## Design Response to SOPA Issues

Project No: 11002  
Project: **3 Murray Rose Avenue**  
Date: 25 January 2013

### Design Response to SOPA Issues: Depth of Building Recesses & the Width of Public Pathways

2 Lower Level 'The Chase' - Future Shared Use Subject to Separate Approval (Ideas only)
1:100

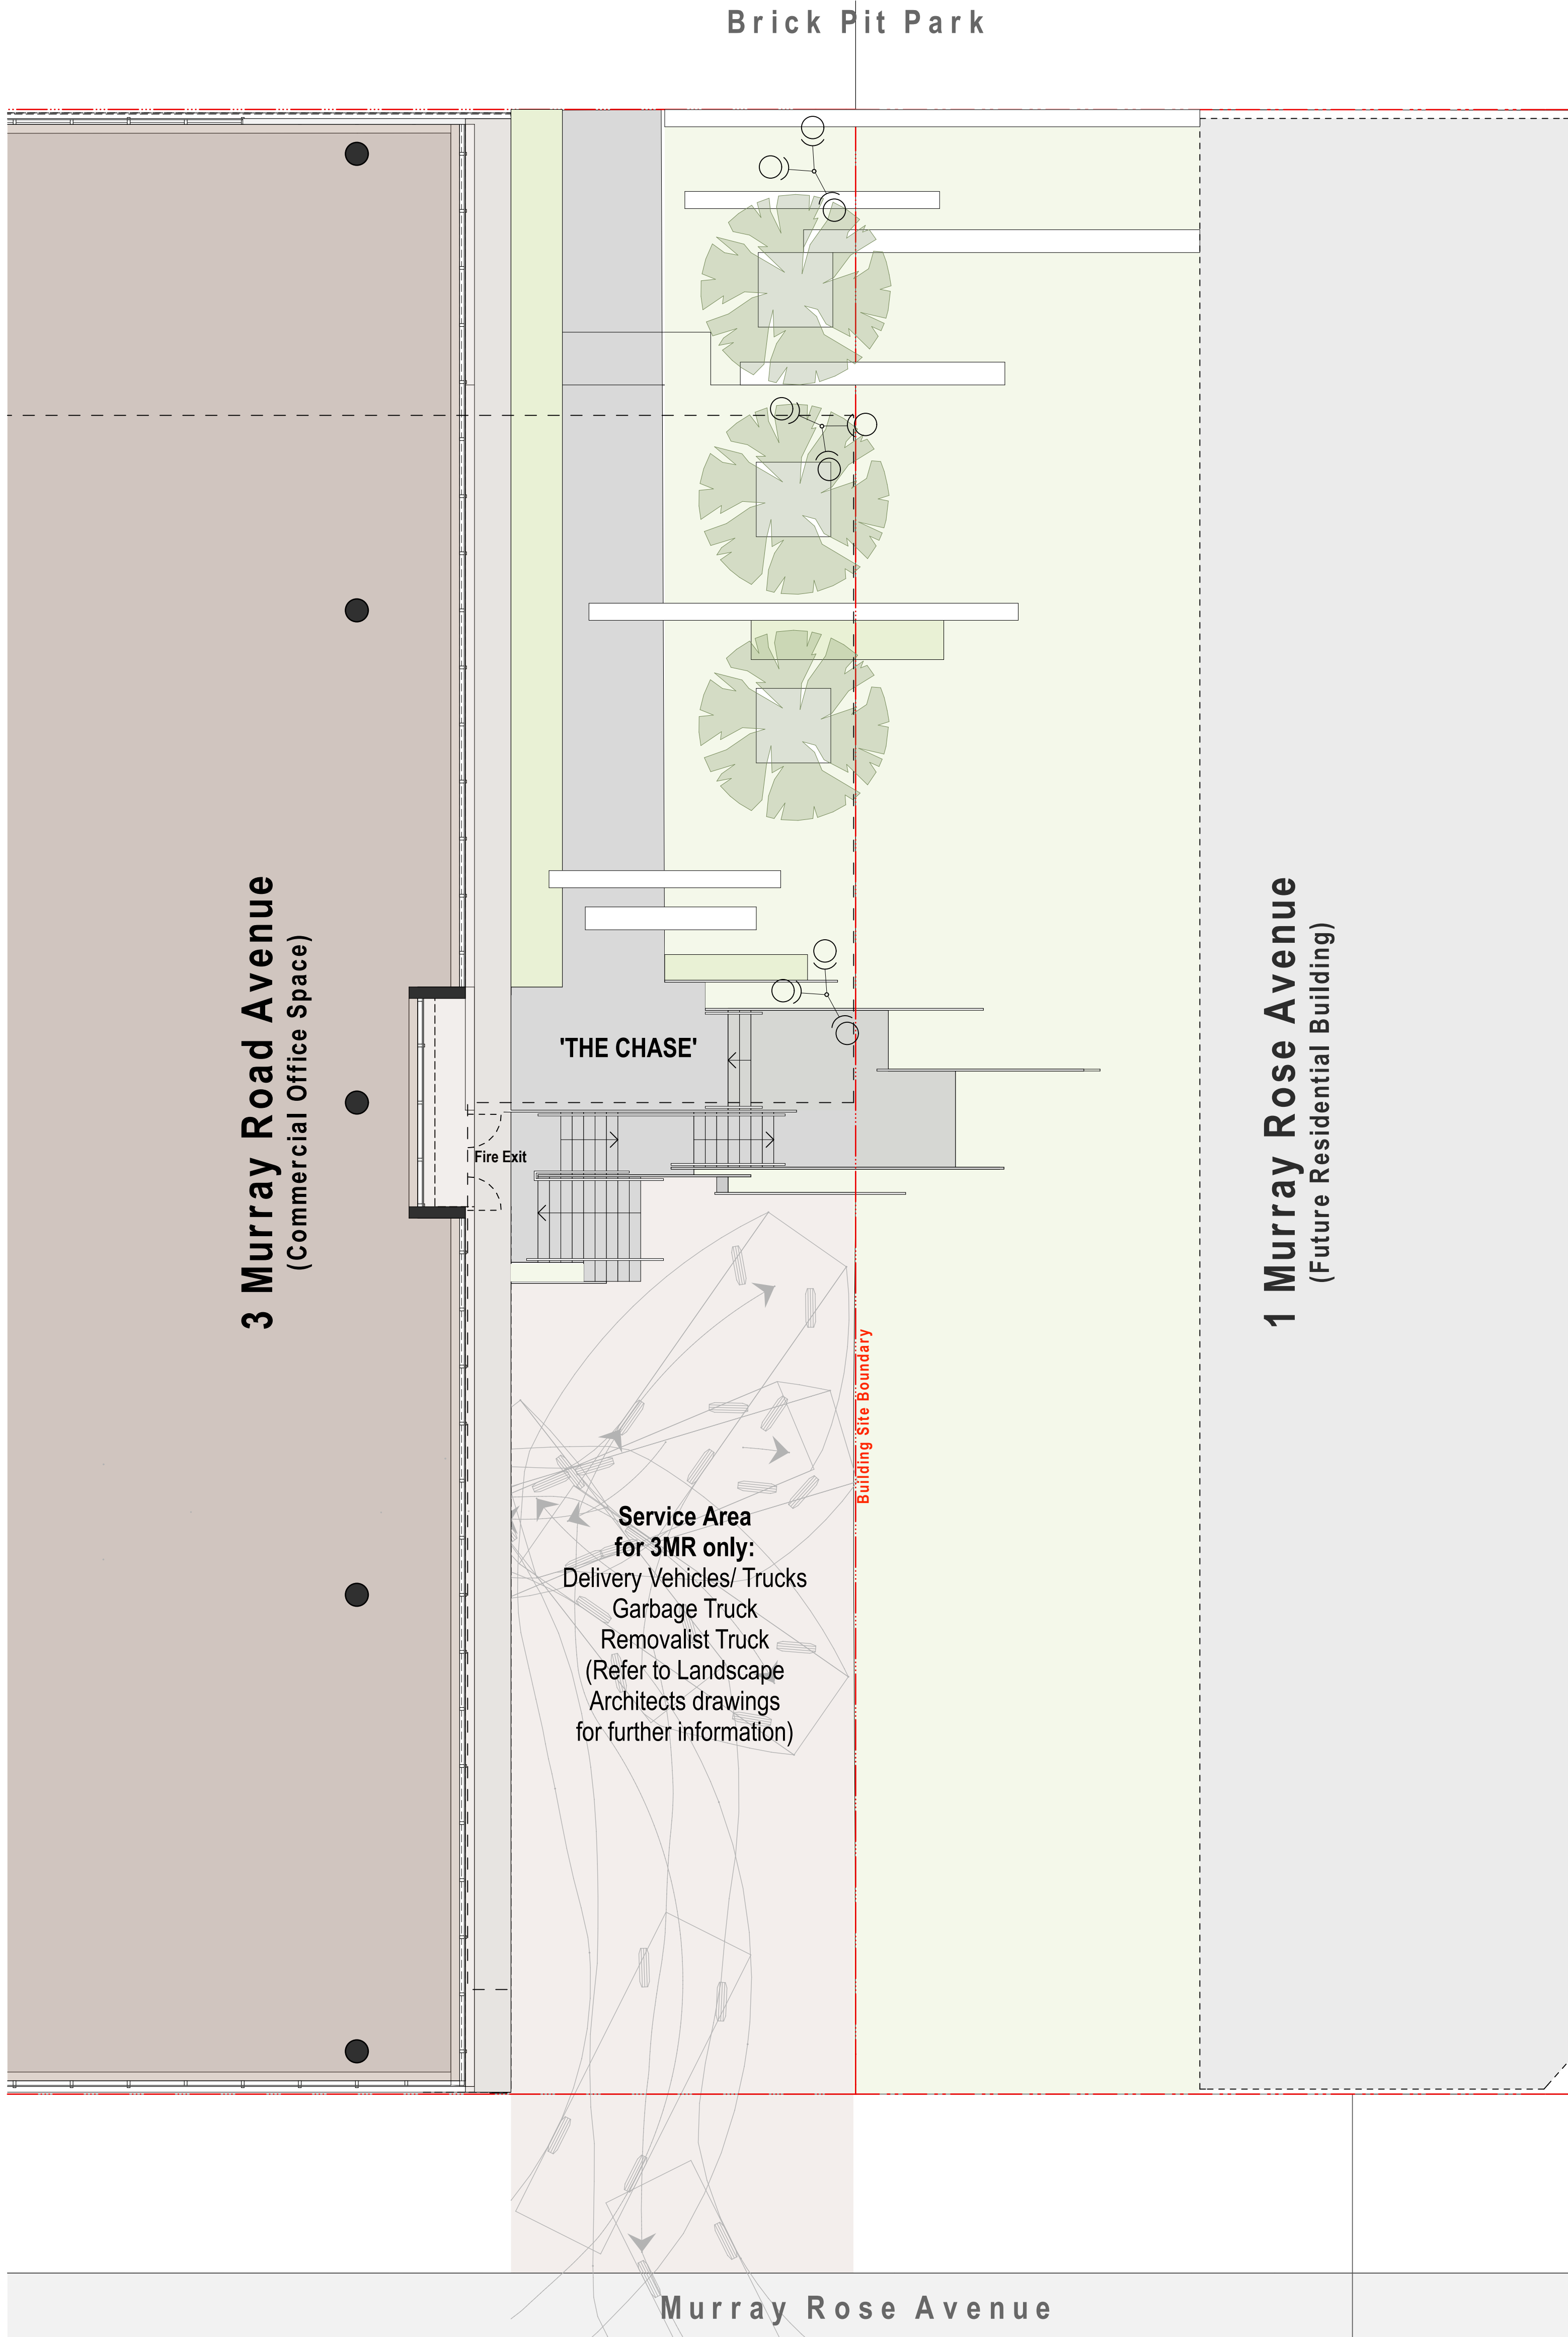
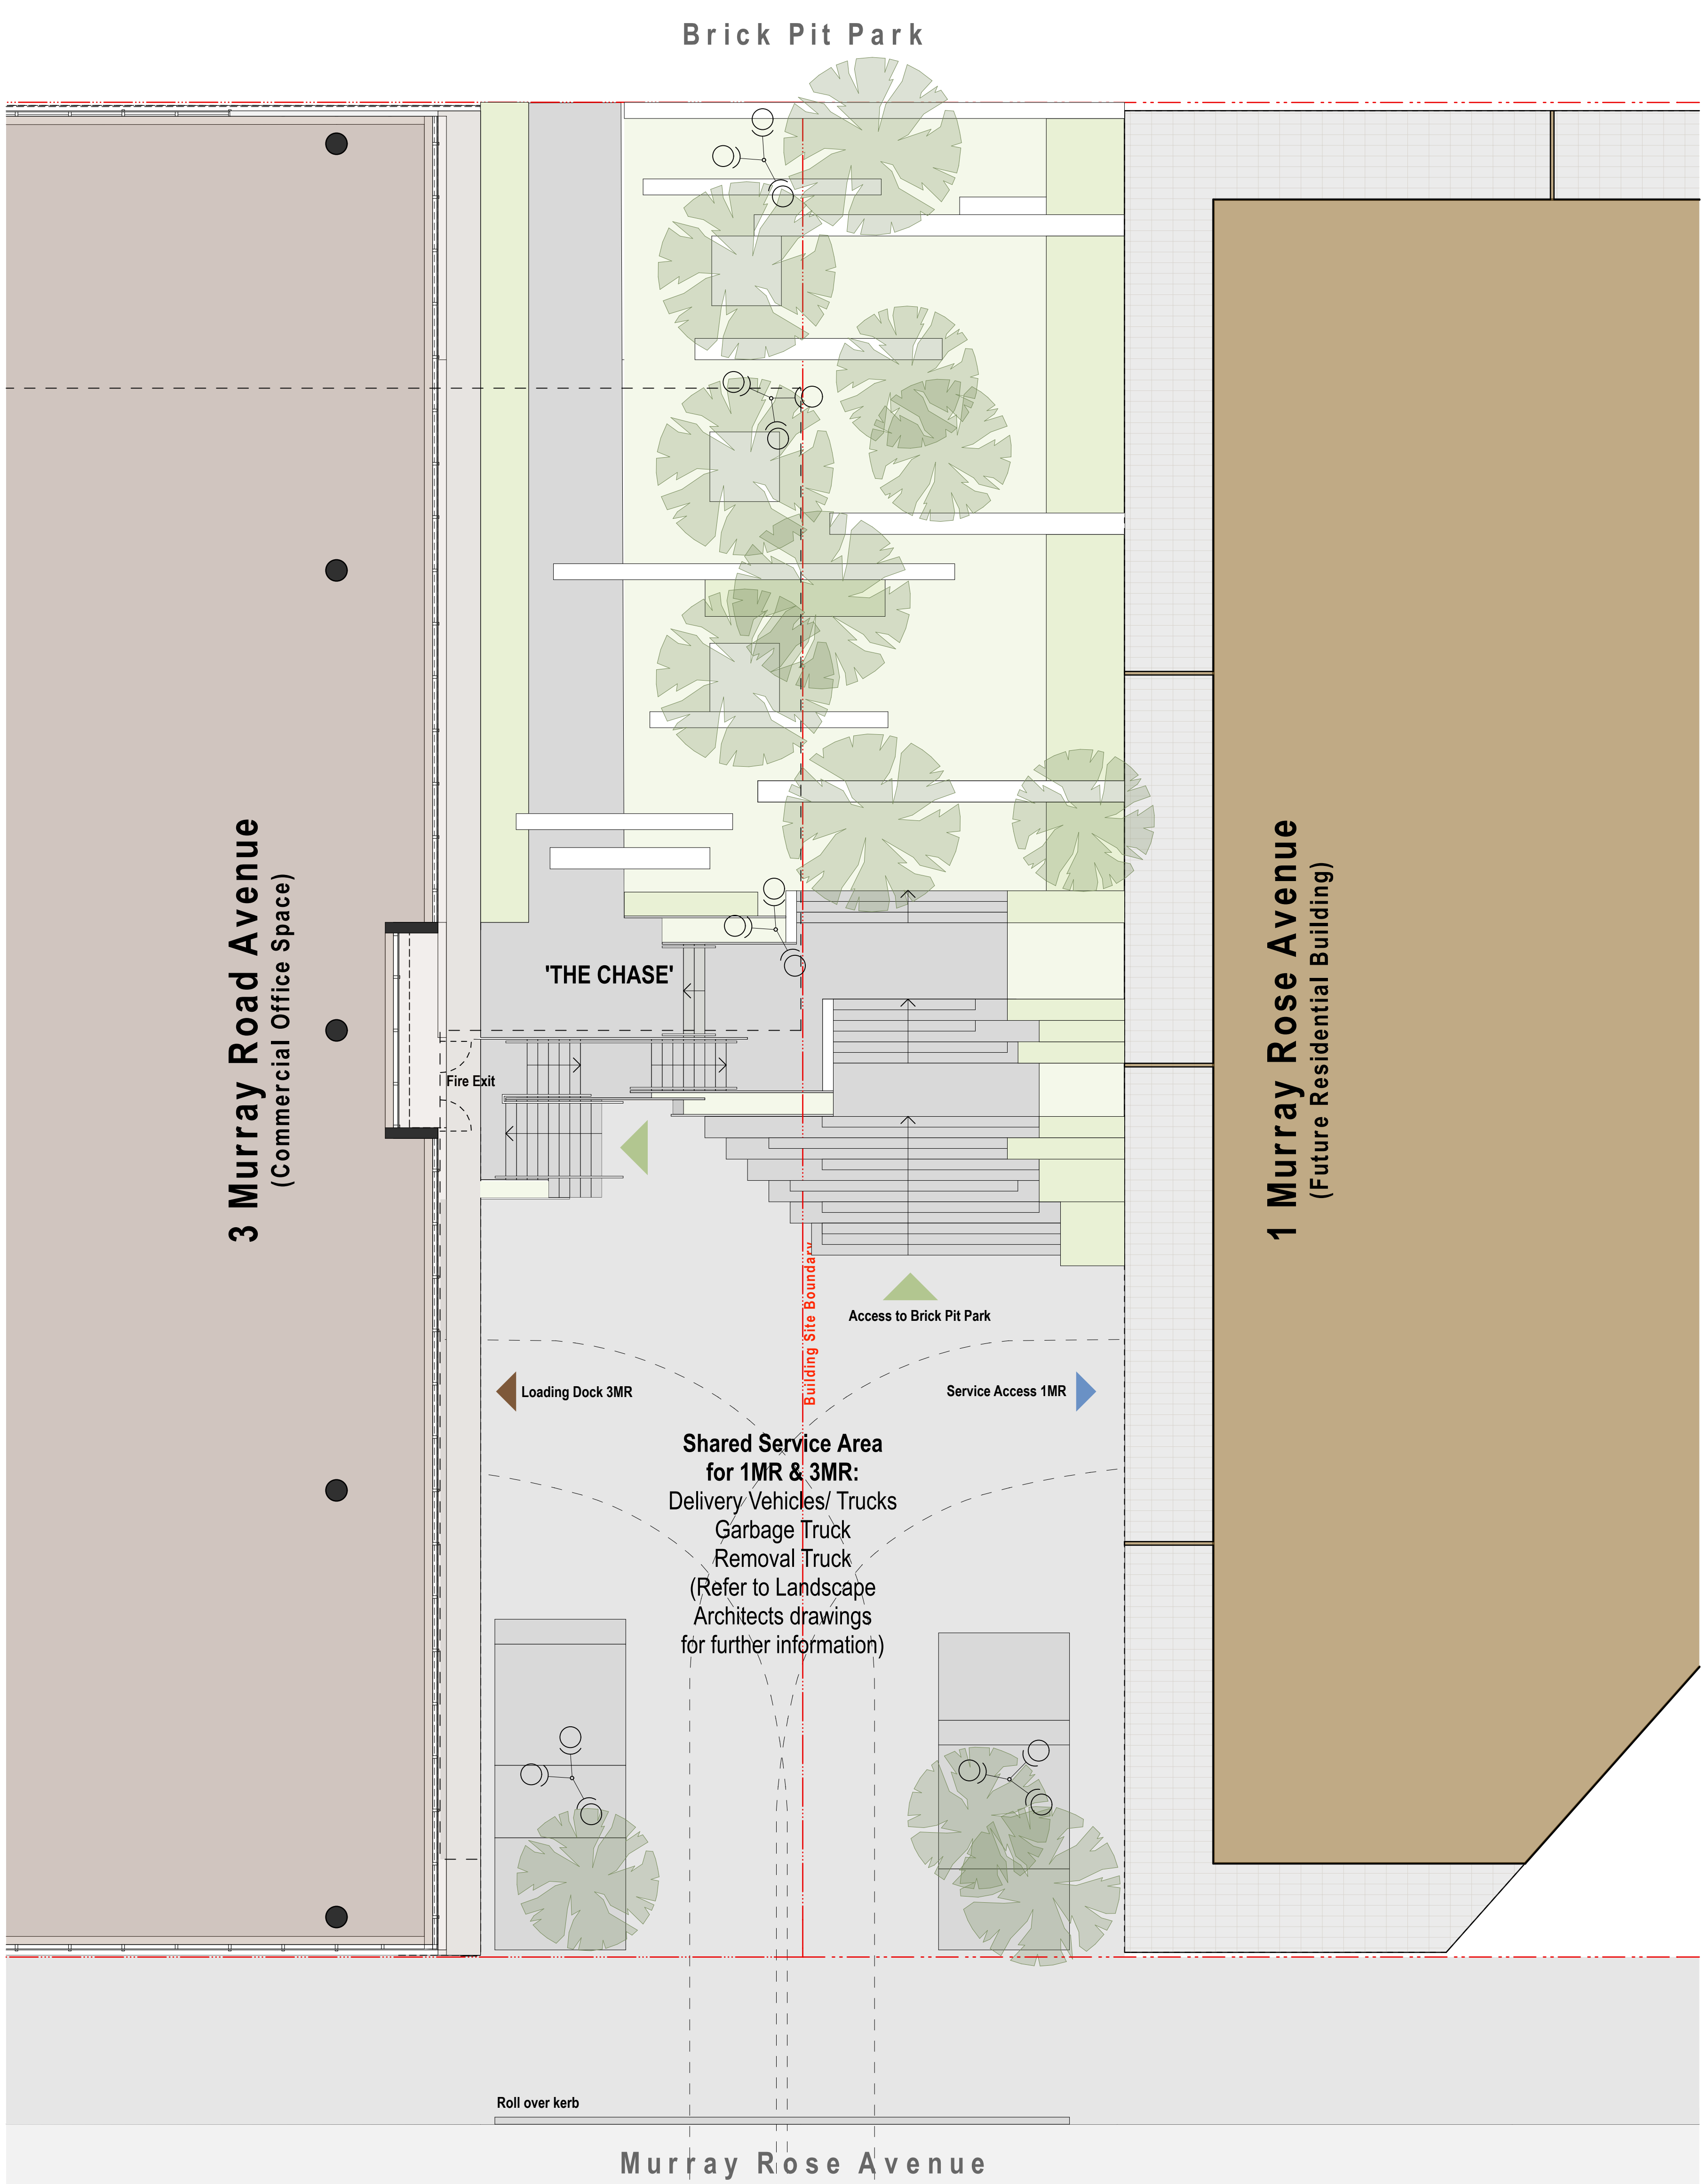
The immediate context, represents only half of 'The Chase', relying on the future development No.1 Murray Rose Avenue to complete this public domain space. Architectural drawings EA108 and EA109 show both immediate and ideas for the future design of 'The Chase'.

When consideration is given to the future design ideas, a publicly accessible pathway, well in excess of 2.0m can be achieved, not to mention significant landscaping and shared drop off / service area for both buildings. However, the immediate context - only half of 'The Chase' - limits the immediate realisation for all of these opportunities. With reference to SOPA correspondence -

the width of the publicly accessible pathway.

Despite this short term restriction the objectives for 'The Cutting' are still achieved avoiding a perfunctory response. The minor numerical variation in the width of the pathway is inconsequential when consideration is given to the overall development of 'The Chase' when complete.

As detailed above we strongly believe that the building recess and the width of public pathway is appropriate with consideration to both the immediate and future context for the site and precinct.
